From: Bob Sharples <Bob.Sharples@sportengland.org>
Sent: 29 April 2022 16:13
To: Andrew Lewis
Cc: Sharon Whiting; Thomas Darlington; Andrew Earnshaw; Stuart Lamb; 'Jason Bowers'; 'Neil Higginson'
Subject: App Ref: 22/00747/OUT - Land at Bicester Road Kidlington - Sport England Ref: PA/22/SE/CL/61234

Thank you for re-consulting Sport England on the above application with additional information: drawing CSA/3263/123 rev D and the revised Design and Access Statement April 2022.

Figure 4.3: Land Use Plan

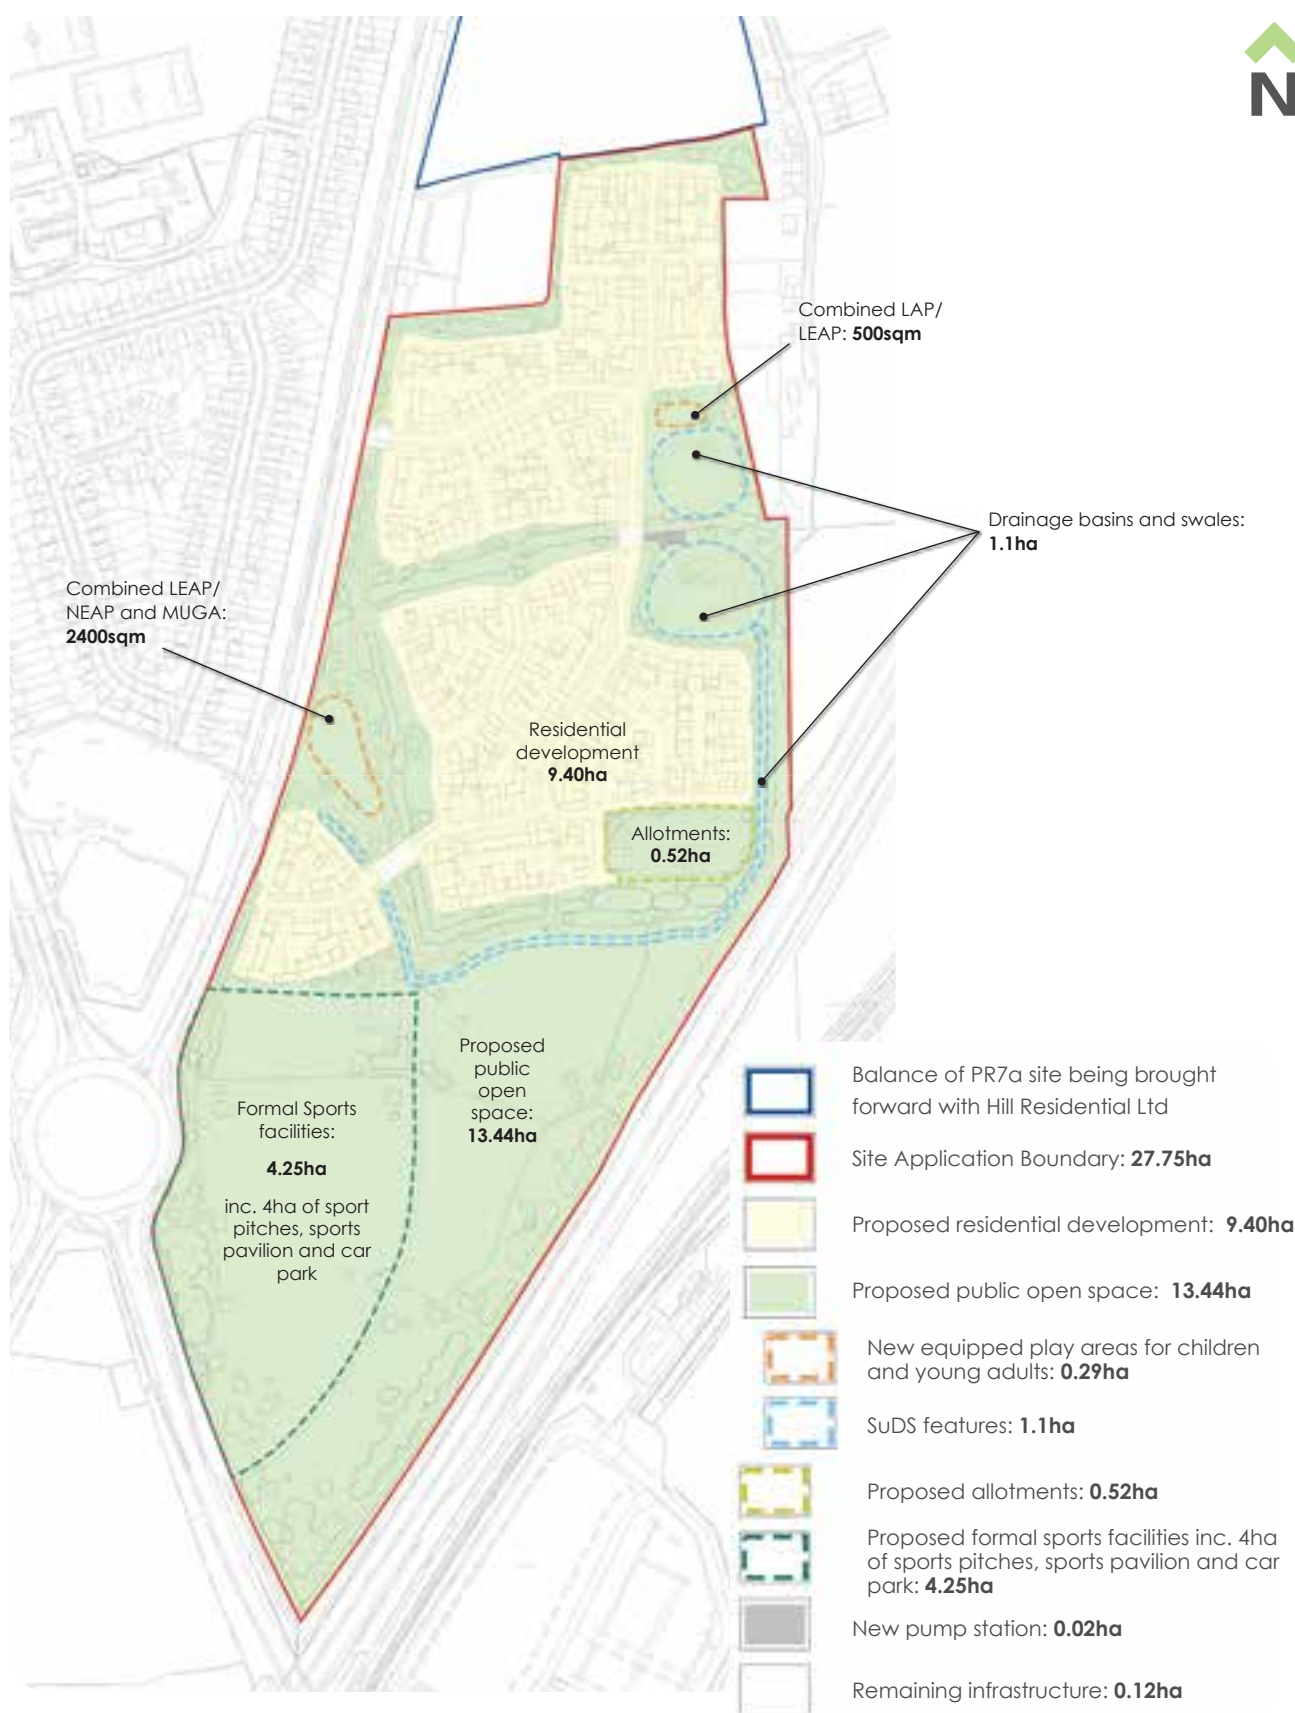
I have reviewed both documents and I am still concerned that the proposed formal sports area is not what been discussed with CDC in the past because as shown it is too small to meet the needs of football in this area of Cherwell.

I note that there is also a discrepancy between the drawing and the D & A of 0.25 hectares – 4.3.5 provision of 4.25 hectares of formal sports facilities and on the drawing : formal sports facilities 4 hectares

Our objection would be overcome if all the land east of the proposed football hub is reallocated to football use.
